**Subject:** RE: Planning Consultation on: BR/81/22/DOC

**Application No:** BR/81/22/DOC  
**Registered:** 6th April 2022  
**Site Address:** 65-71 Upper Bognor Road Bognor Regis PO21 1HR  
**Description of Works:** Approval of details reserved by condition imposed under BR/252/21/PL relating to conditions 6-surface water drainage and 9-programme of archaeological works.

At this stage we **would not recommend discharge of conditions** until the following comments are addressed.

FOR CONTINUATION SEE DRAWING P1847-BAK-XX-XX-DR-C-502

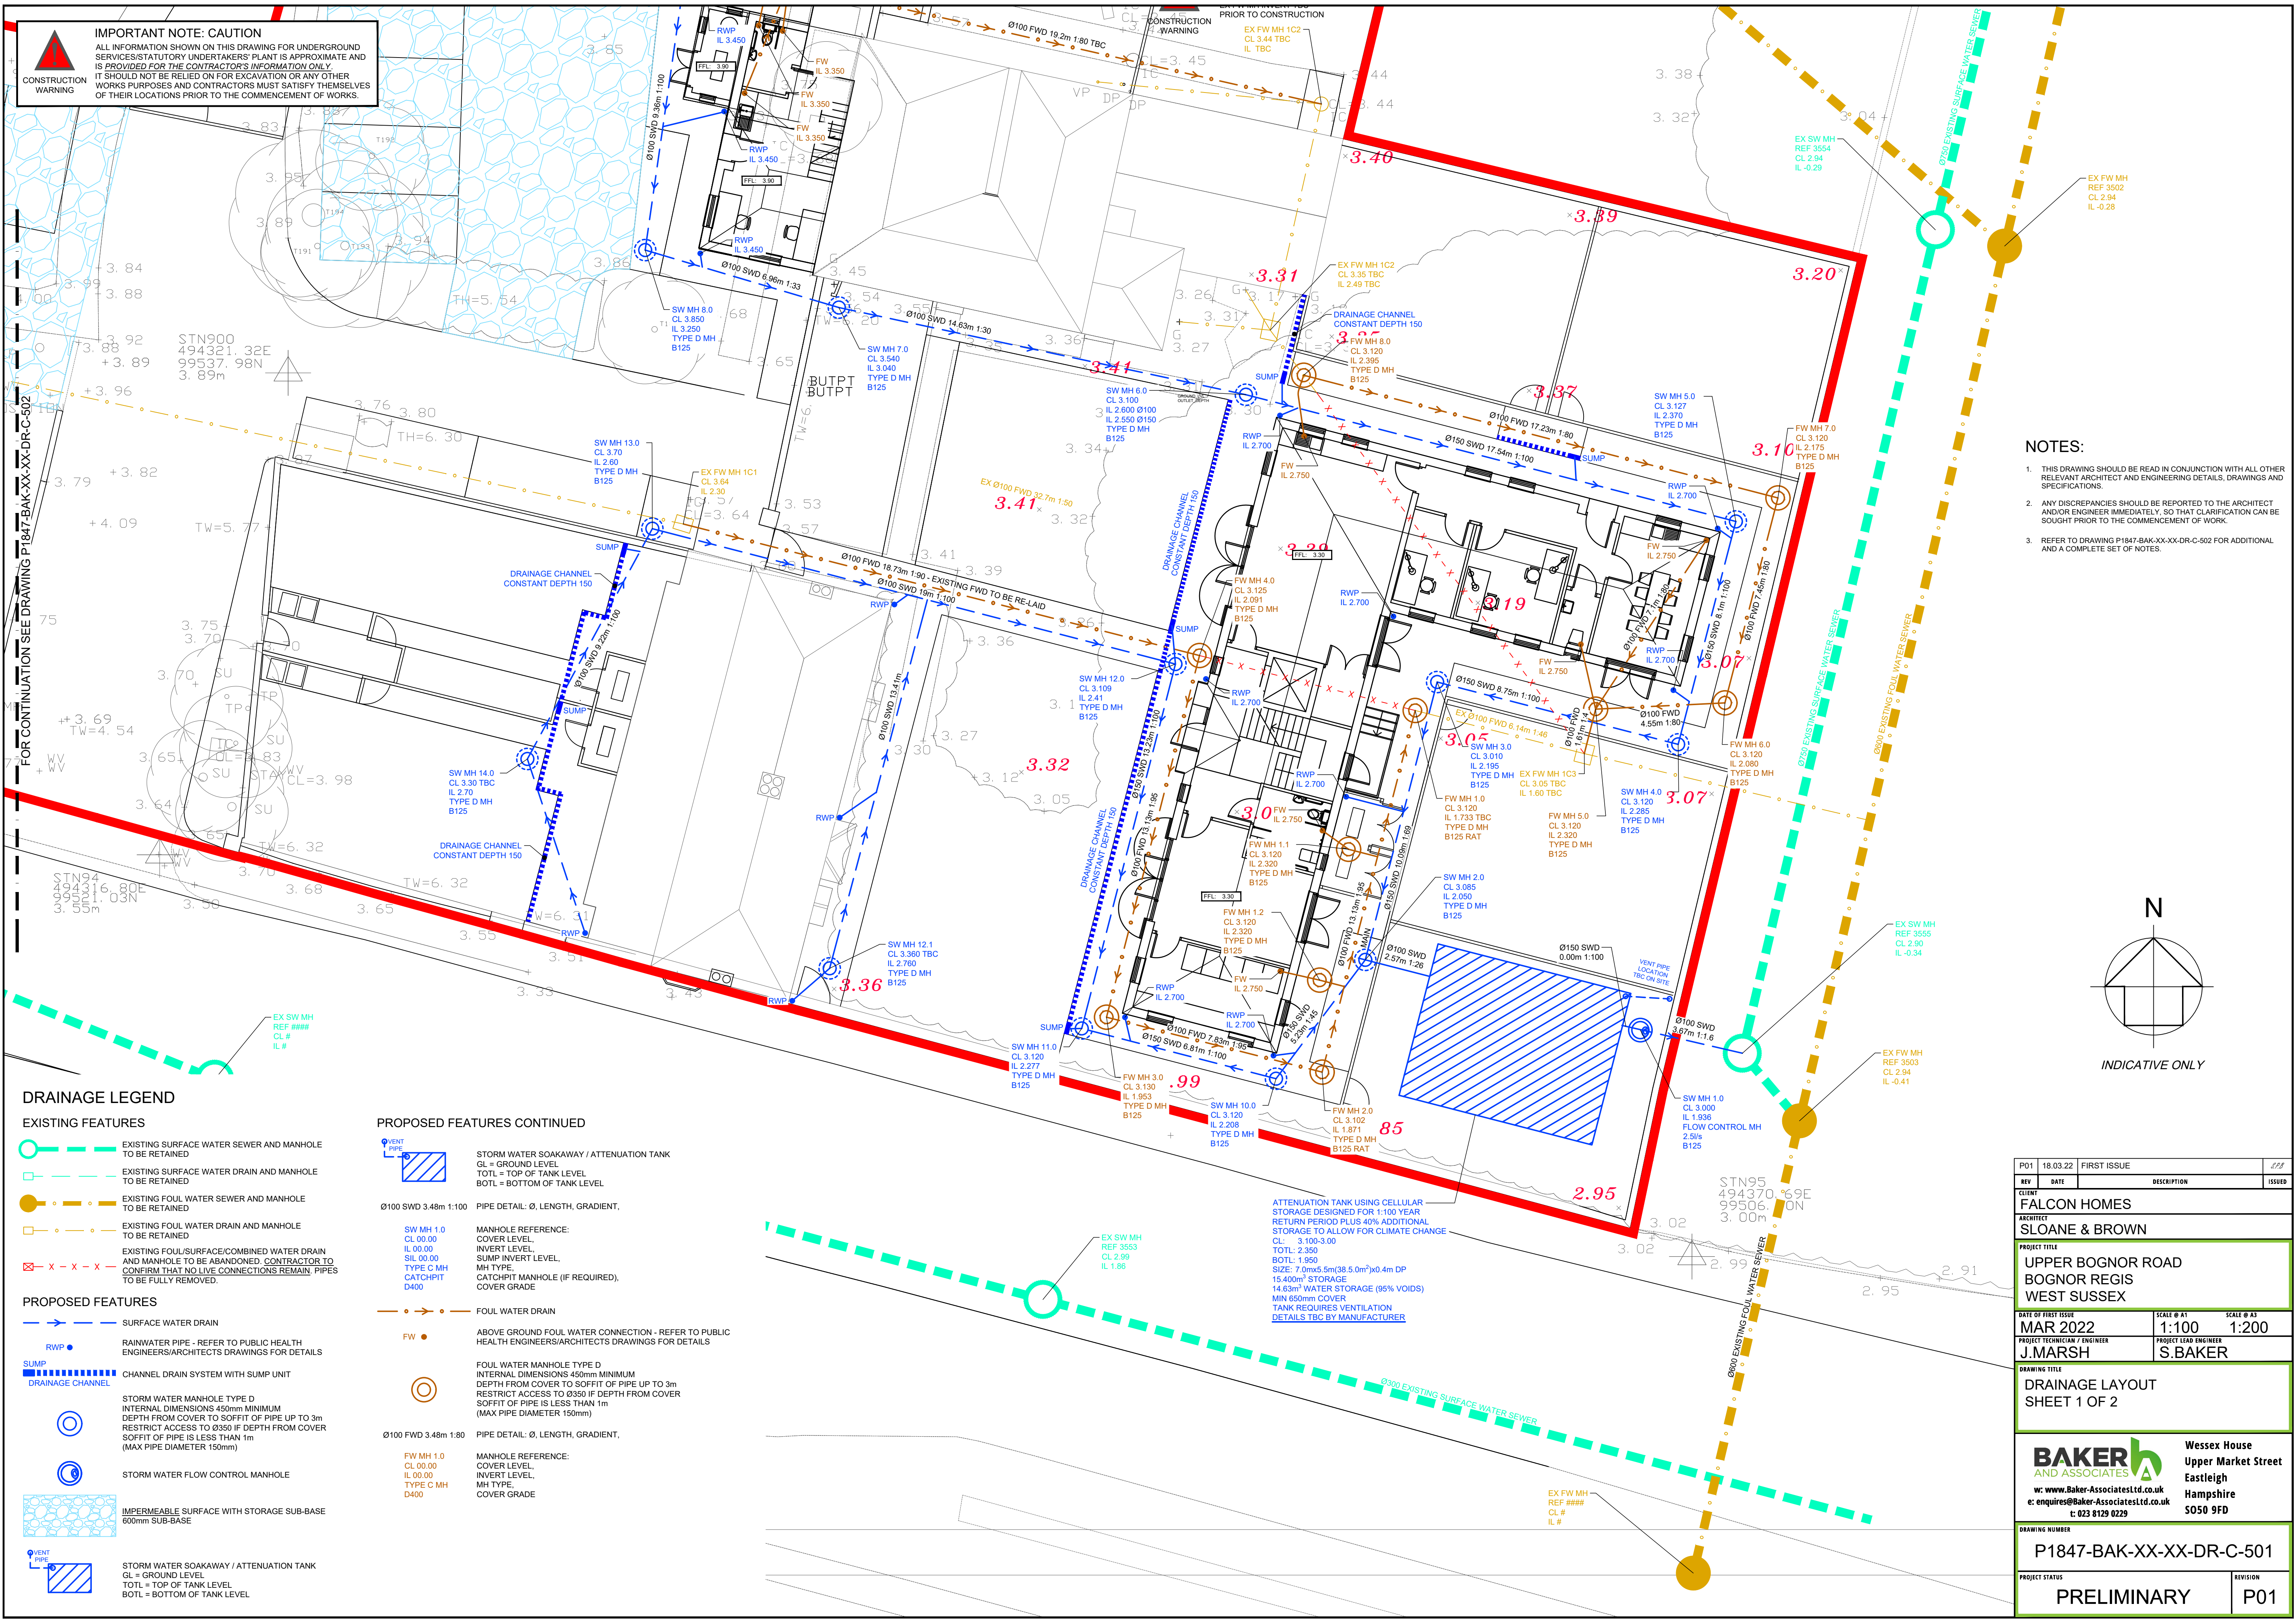
1. The proposed drainage is reliant on a connection to a surface water sewer which shows characteristics consistent with it being an error on Southern Waters mapping system. As a result, we would request the applicant confirms the drainage network in this location with a survey.

- We believe the Southern Water mapping is erroneous and that this error has significant implications for the delivery of the drainage system, as shown on the drainage plans provided.

- We require evidence from the applicant that the outfall intended for use does actually exist as shown on the drainage plans and is not an error on the mapping.

- Notwithstanding this, even if the network is shown as Southern Water indicate, we would refuse a connection into the large surface water pipe as currently shown, as it appears that this pipe discharges directly into the adjacent foul network. Consequently, revisions to the point of connection between the site and public sewer system are likely to be required.

14. The pipe between MH11 and MH10 is shown to drain uphill. This should be corrected.
  15. Water quality criteria have not been met. Information on the water treatment provided by the scheme should be provided.

18. The crate type and manufacturer specification should be provided.
  19. Catchpits should be included within the design (upstream of the geo-cellular storage tank), and design details provided.

- Overflow systems can be used as an alternative, but will require justification and are subject to approval.
  22. We note that the 'sump available' option has been used in the drainage model/calculations. If a Hydro-Brake with sump available is specified, as is indicated by the results sheets submitted, this sump will need to be included on the detailed drainage drawings.

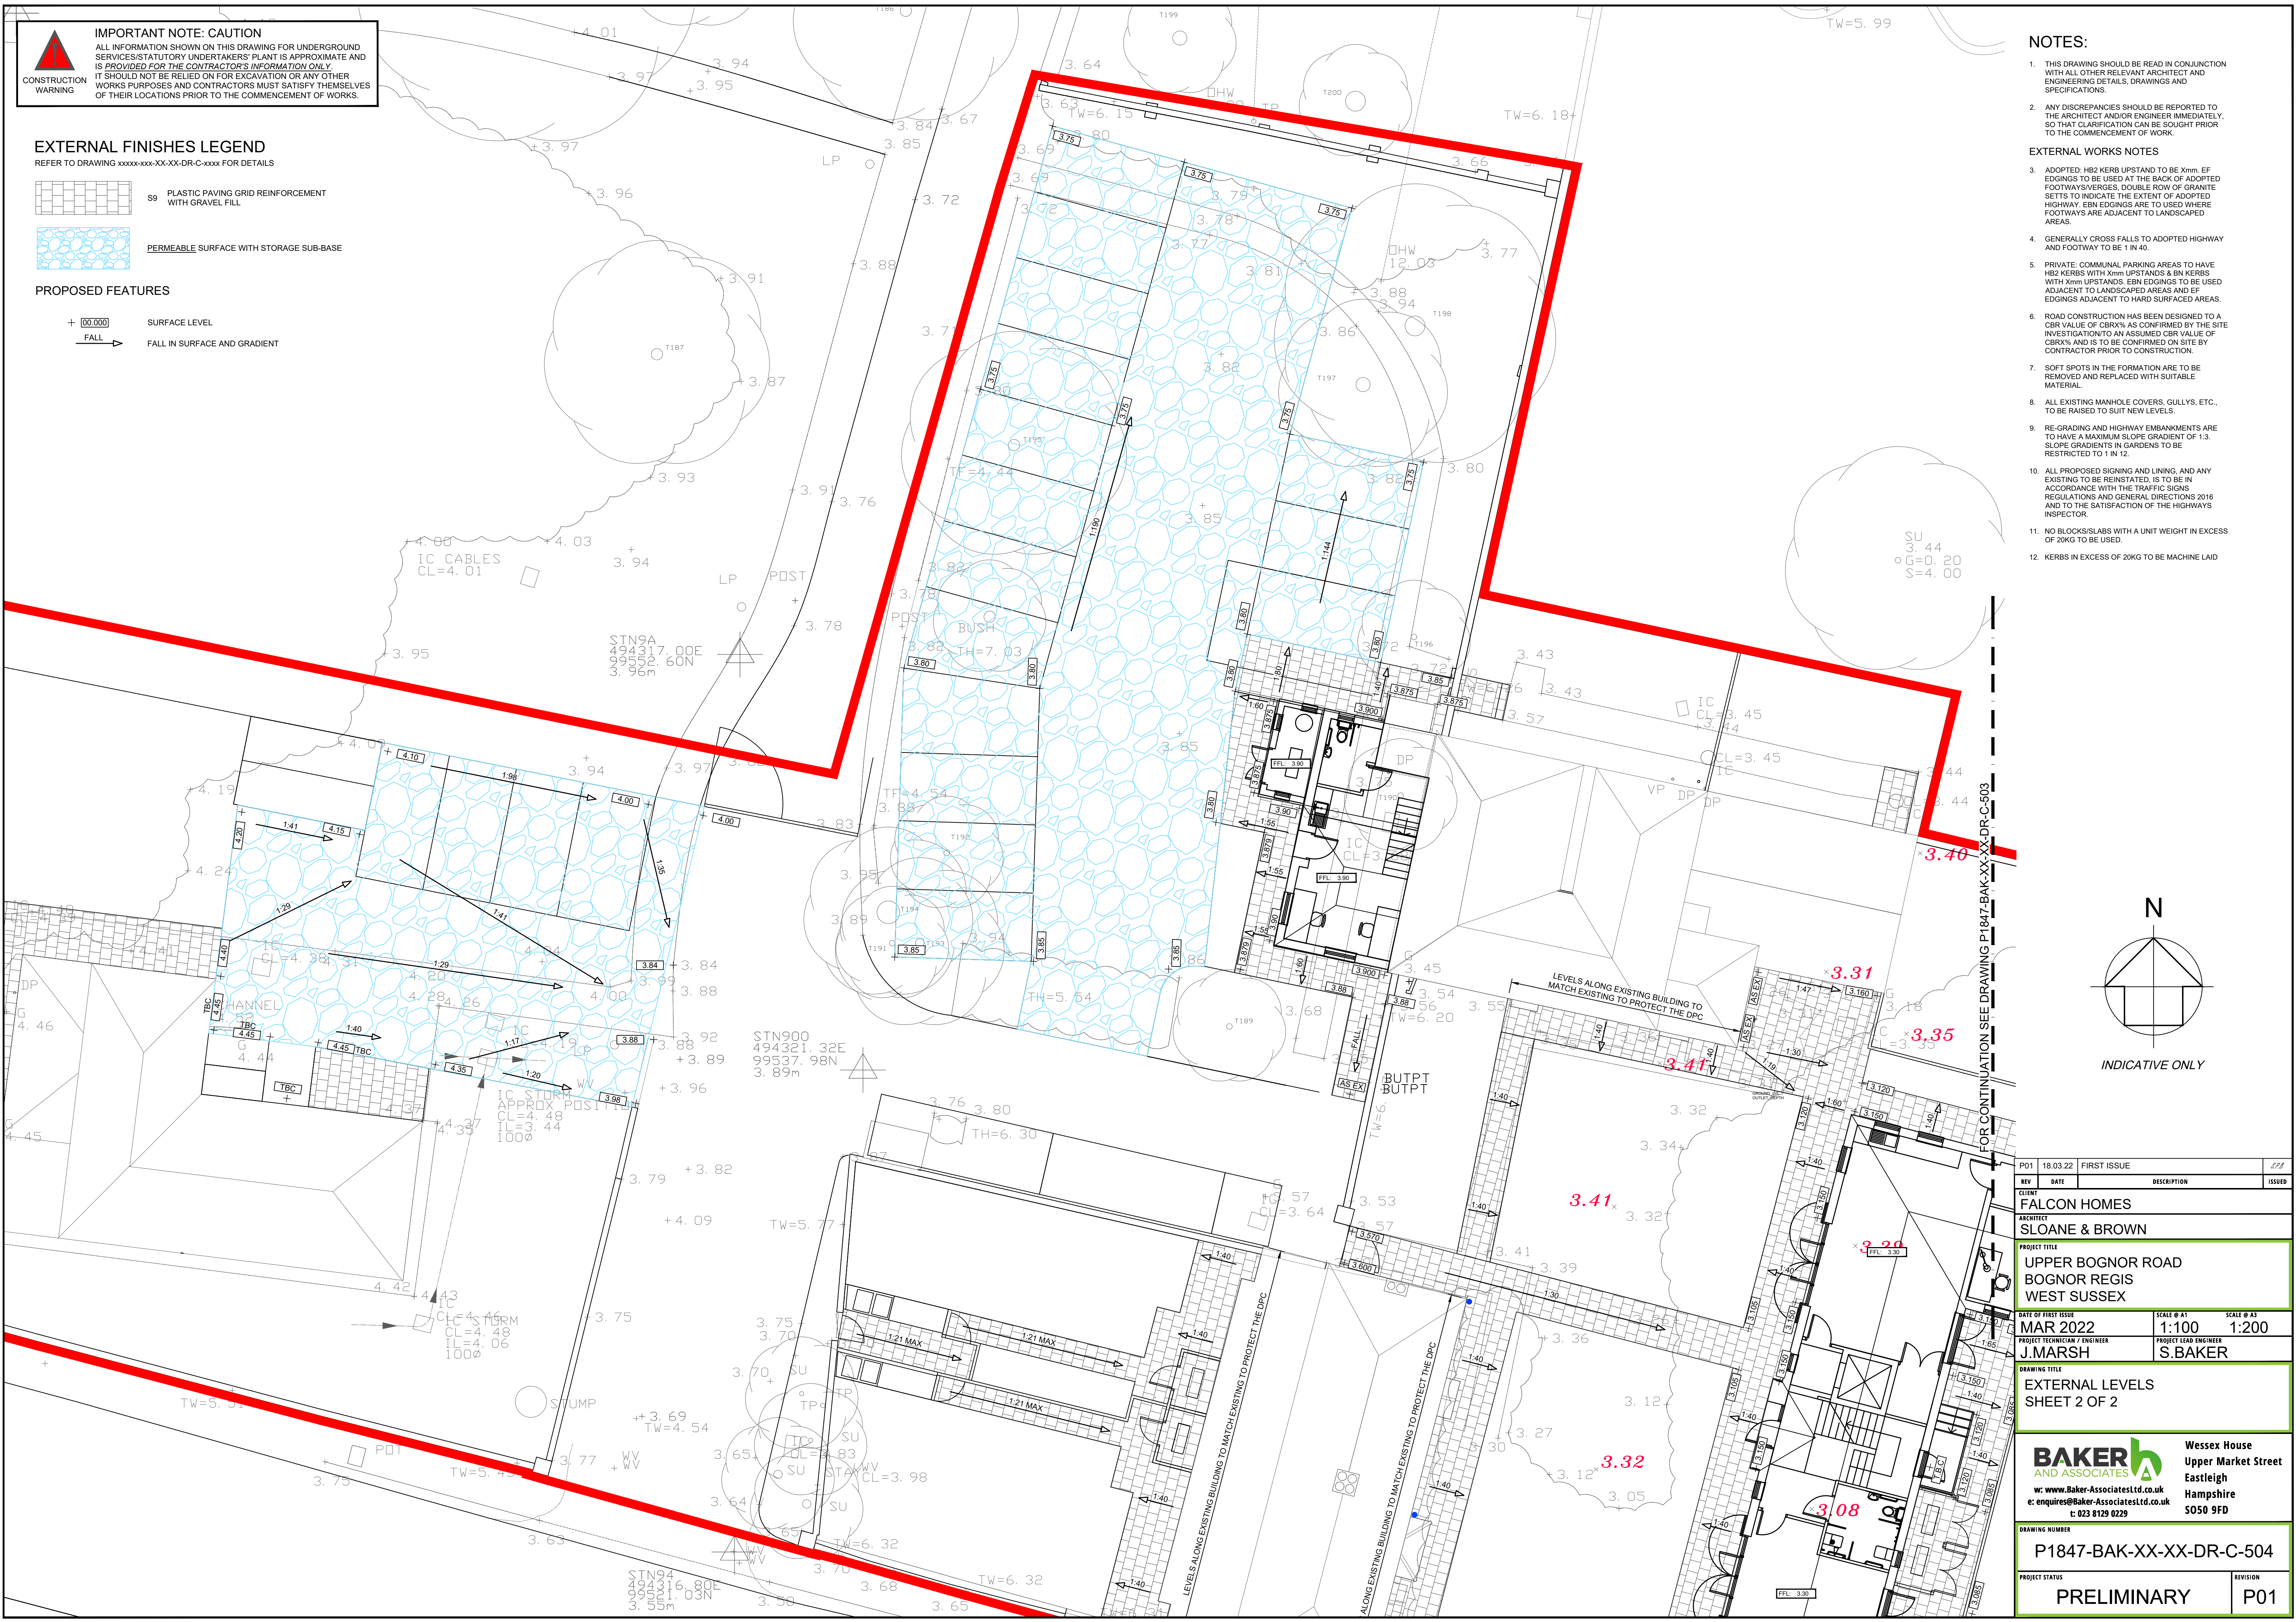
7. The Type 1 sub-base proposed for the carparking needs to be replaced by an aggregate with a low content on fine material, e.g. Type 3 aggregate to ensure sufficient infiltration occurs.

TYPICAL DETAIL FOR ATTENUATION TANK

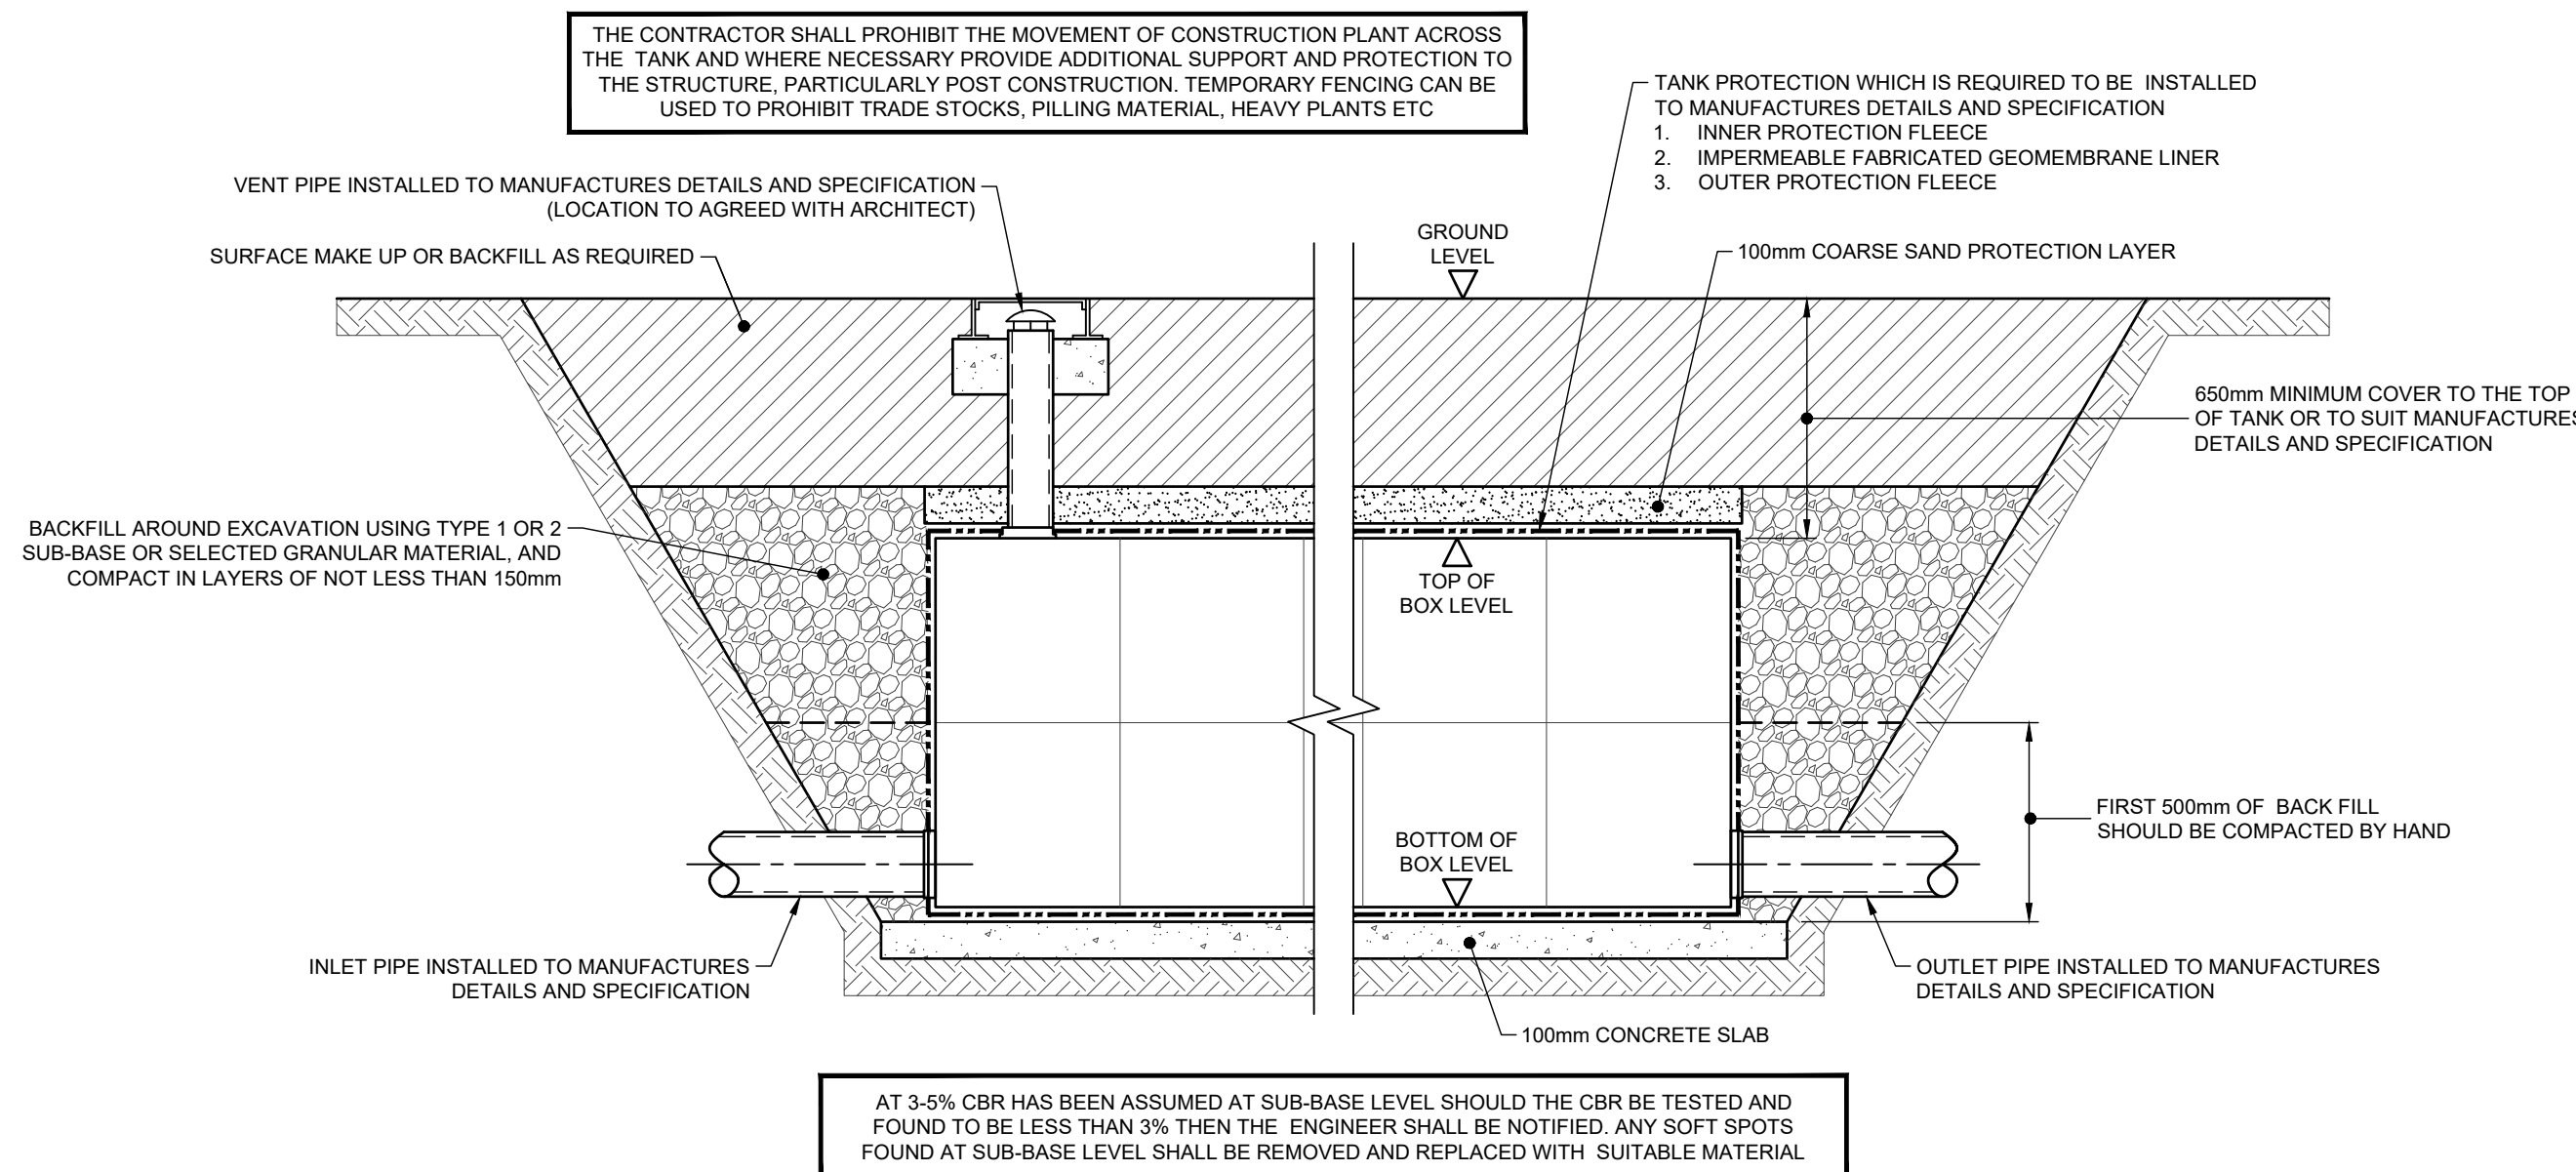
- The type of geotextile membrane (impermeable or permeable) should be stated on the retention system section drawing.
  - Details of the proposed flow control device should be provided.

- It is recognised that if unachievable and justifiable, 2.5l/s would be considered acceptable given the existing site is partly developed.
  11. The inlets into the geo-cellular storage tank must be designed to ensure they are above the maximum water level in the tank during the critical duration storm with a 1:10 year return period. The section drawing of the attenuation tank, and invert levels on the drainage drawing suggest this has not been achieved.

- Even in the event that the worst case groundwater level is assumed to be 1.1m BGL, the base of the tank is shown to be almost at, or below the water table.

- Details of how the geo-cellular storage tank will be inspected during maintenance should be provided, e.g. will this be undertaken by CCTV drainage survey similar to the pipework?, or will the tank include access covers for visual inspection?
